Application by Fosse Green Energy Ltd for an order granting development consent for the Fosse Green Energy solar farm

**Deadline 5 –
Comments on Submissions and
Information Received at Deadline 4**

North Kesteven District Council

28th April 2026

Figure 3-2A SHEET 1 03

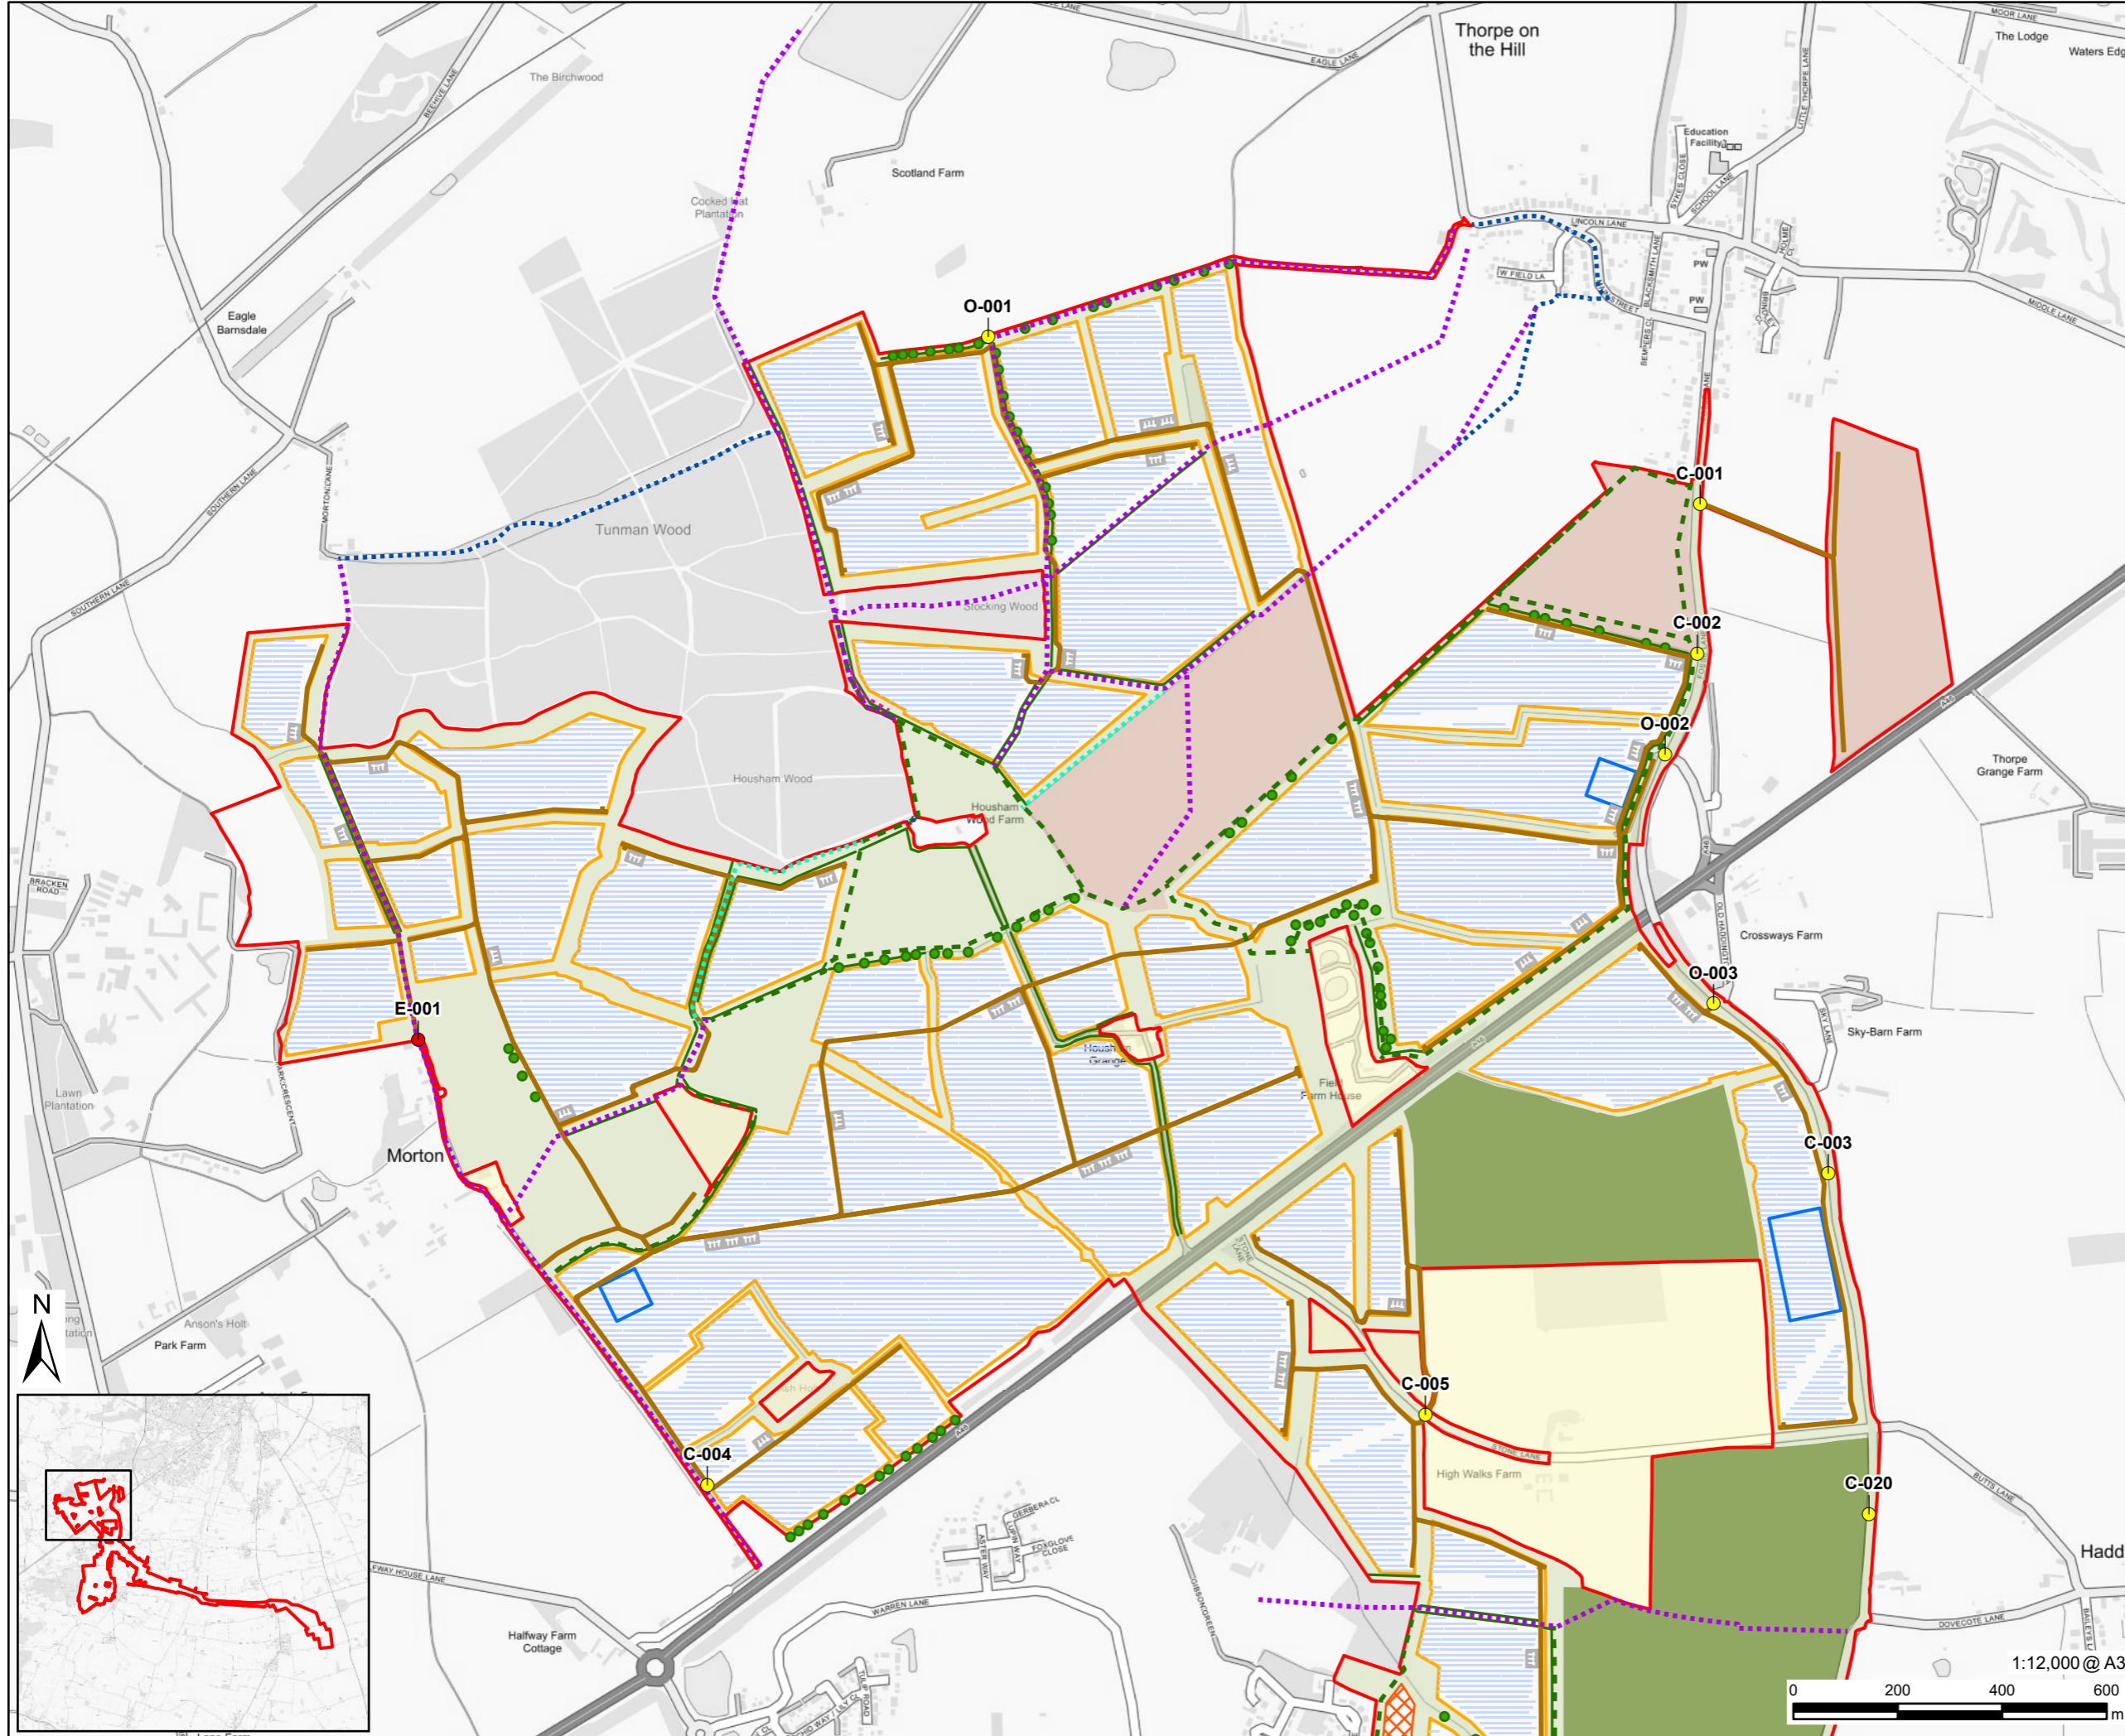
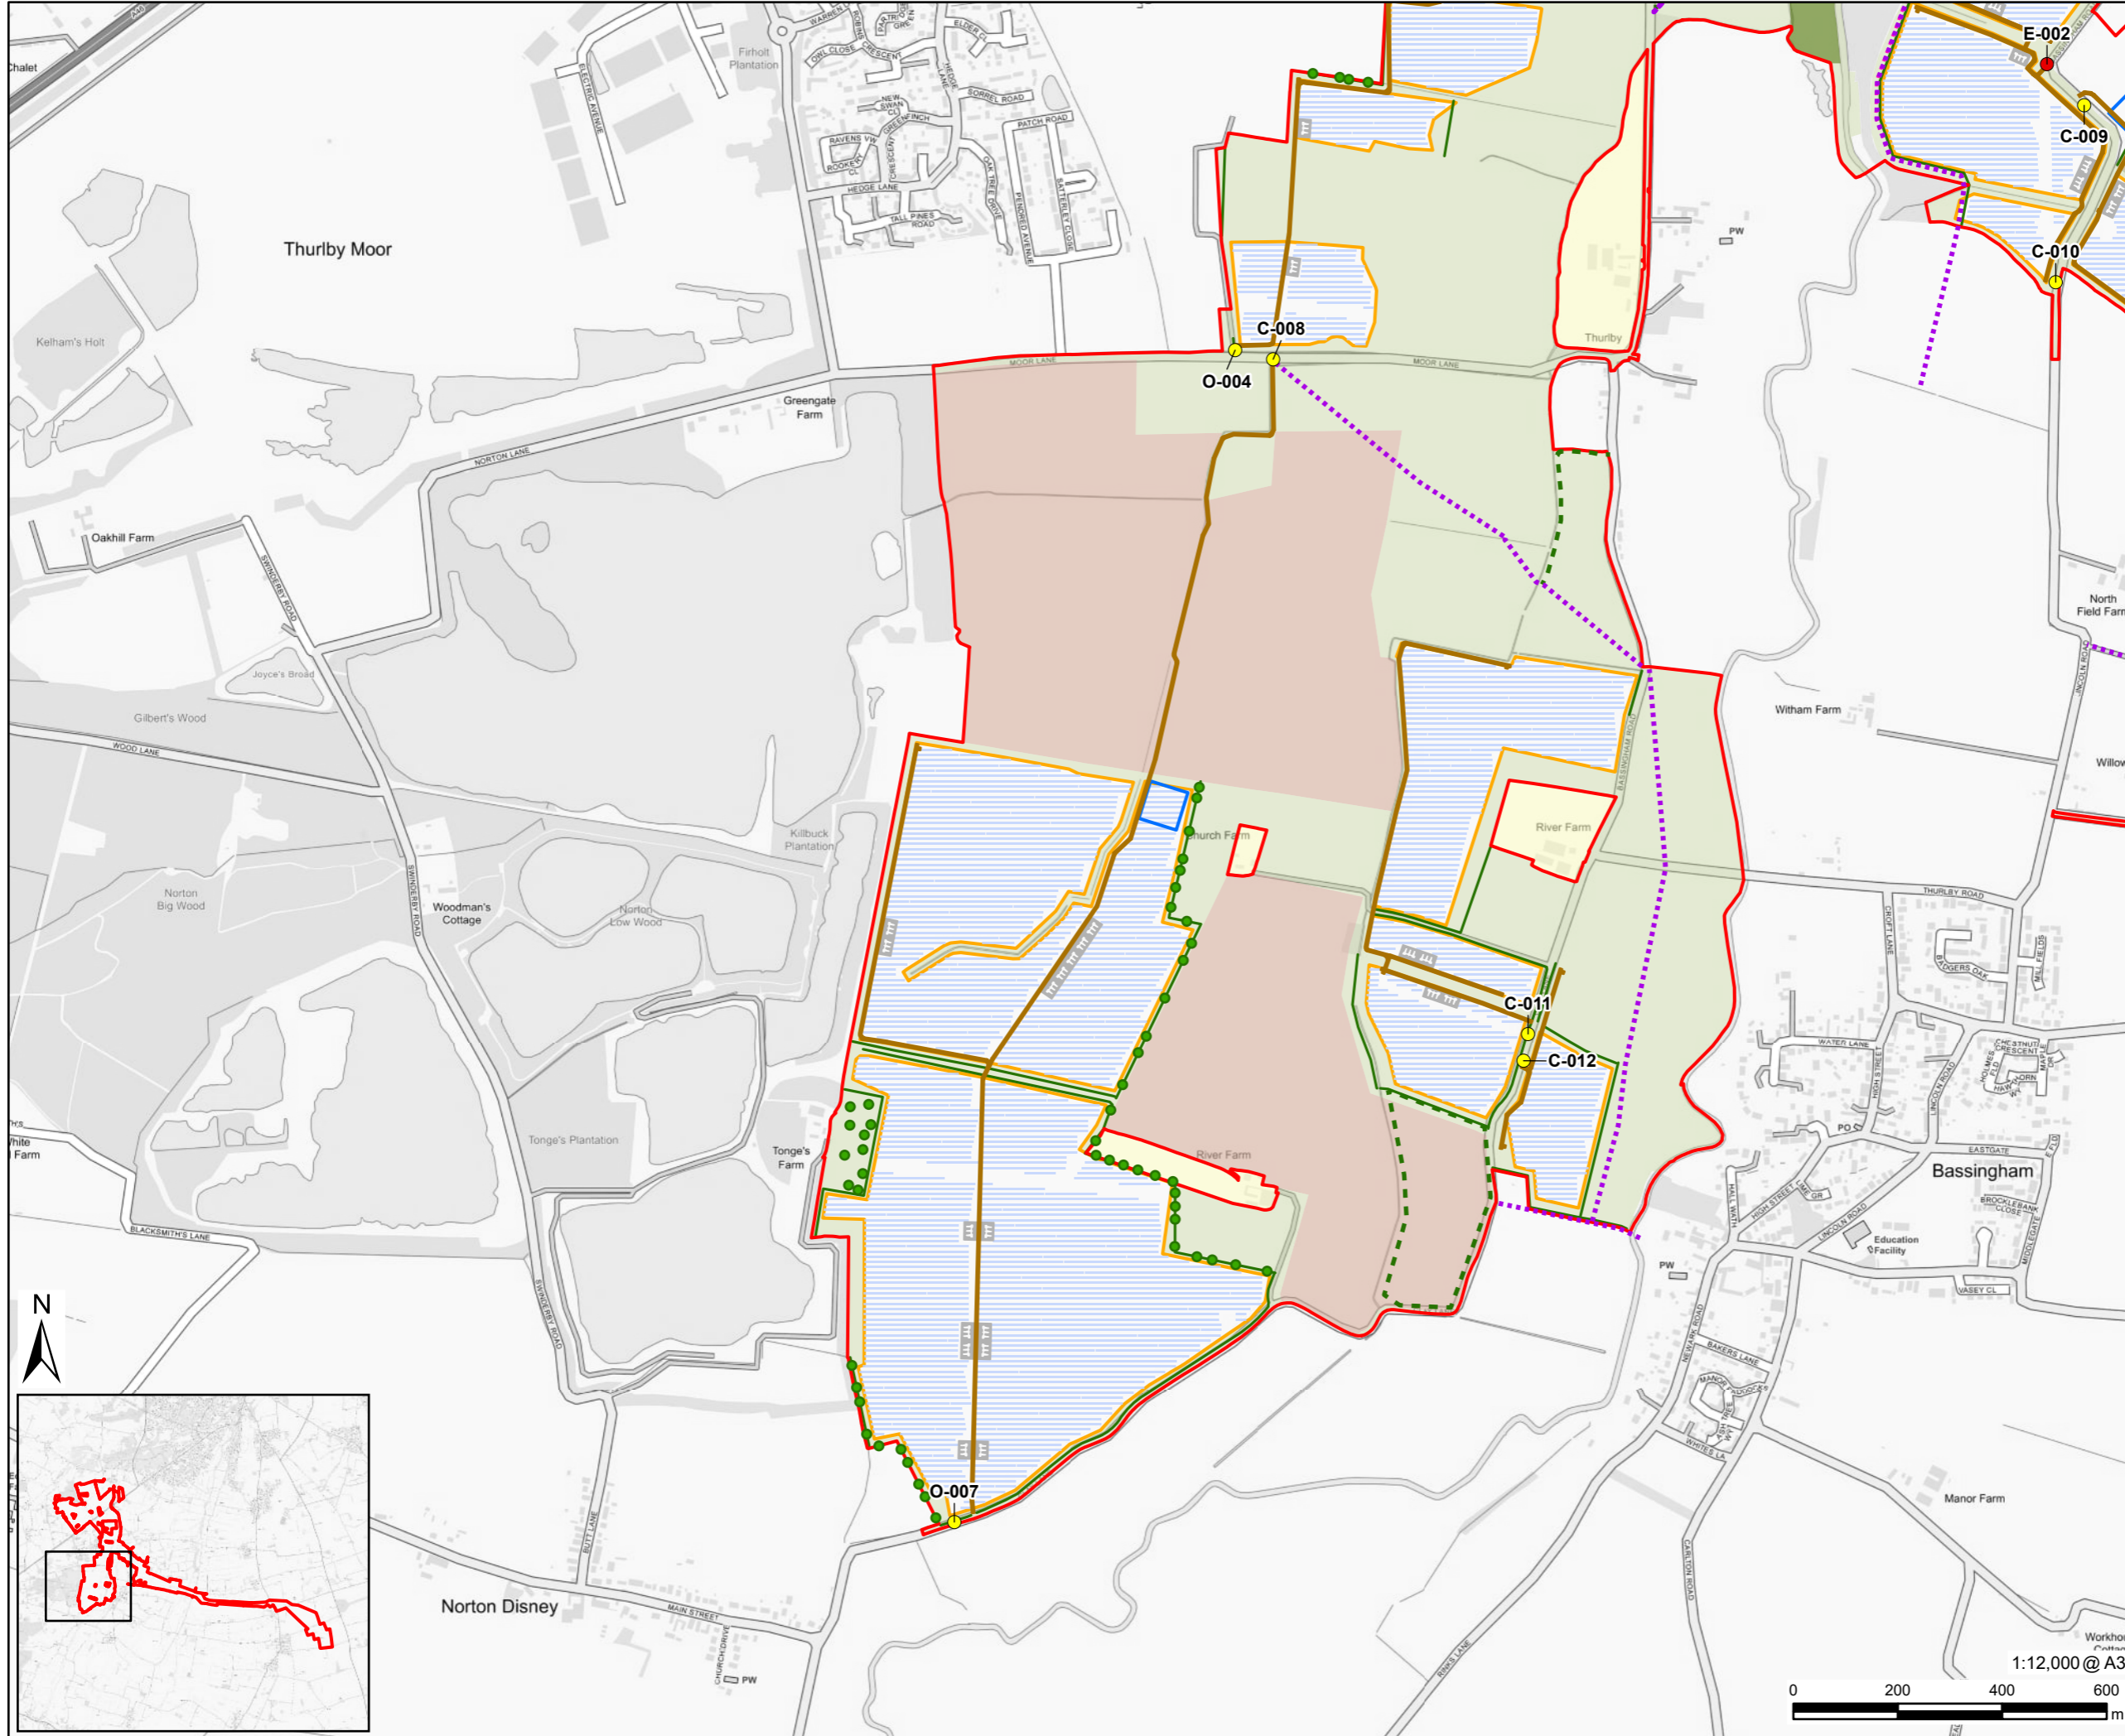
20. The Applicant has submitted the following drawings as indicating its revised approach to the provision of permissive paths:
 - REP4-006 : Figure 3-2A Indicative Fixed South-facing Site Layout Plan

- REP4-007 : Figure 3-2B Indicative Single Axis Tracker Site Layout Plan
21. These drawings are labelled 'indicative', and are not intended to be certified documents. The Council looks forward to having sight of the final permissive path proposals on the Landscape Mitigation Plan contained in the Framework Landscape and Ecological Management Plan, as it is that document which is referred to in the definition of Permissive Paths in the draft DCO, article 2 (REP3A-029). Also showing the permissive paths on the Streets, Rights of Way and Access Plans will be helpful in showing how they connect to the statutory public rights of way network.

23. The changes to the permissive path routes in the area around Thorpe on the Hill, Morton and Tunman Wood represent an overall minor improvement on previous

proposals. The loss of some lengths of the existing Stepping Out permissive routes – for instance the valuable walk along the southern side of Housham Wood – is offset by the retention of the length of permissive path alongside the eastern side of the wood north of Housham Wood Farm. The new route also avoids “funnelling” walkers between panel arrays heading south from Housham Wood; but on the other hand the loss of a length of permissive path to the east of Housham Wood Farm means directing walkers along the public rights of way immediately to the north, where they would have to pass between areas of panel arrays.

24. These changes do not significantly reduce the adverse effects on the experience for users of the two Stepping Out Walks: Morton and Tunman Wood, and Thorpe on the Hill. It is clear that users would experience the loss of open, undeveloped and wide rural views – a major factor in the design and promotion of these walks. The Applicant has never properly acknowledged the value of these walks in terms of their potential to deliver on recreation, mental and physical health, and tourism objectives. Those effects need to be fully mitigated and compensated for.

25. In terms of the total length of permissive path offered, the Applicant has measured this to be 10.2km. Whilst there are limitations with the scale and accuracy of the plans provided, the Council has measured the total length of permissive path as being 9.8km. But in any case, there are significant limitations to the Applicant’s approach which this highlights. Whilst the provision of permissive paths in general is welcome, the failure to recognise the value of and impacts on the Stepping Out Walks in particular is a deficiency of the application. For instance, the permissive path proposed alongside the A46 may be of value to some, especially the occupants of the caravan park nearby. However, in terms of views and noise, that path would never have been selected as part of a Stepping Out Walk.
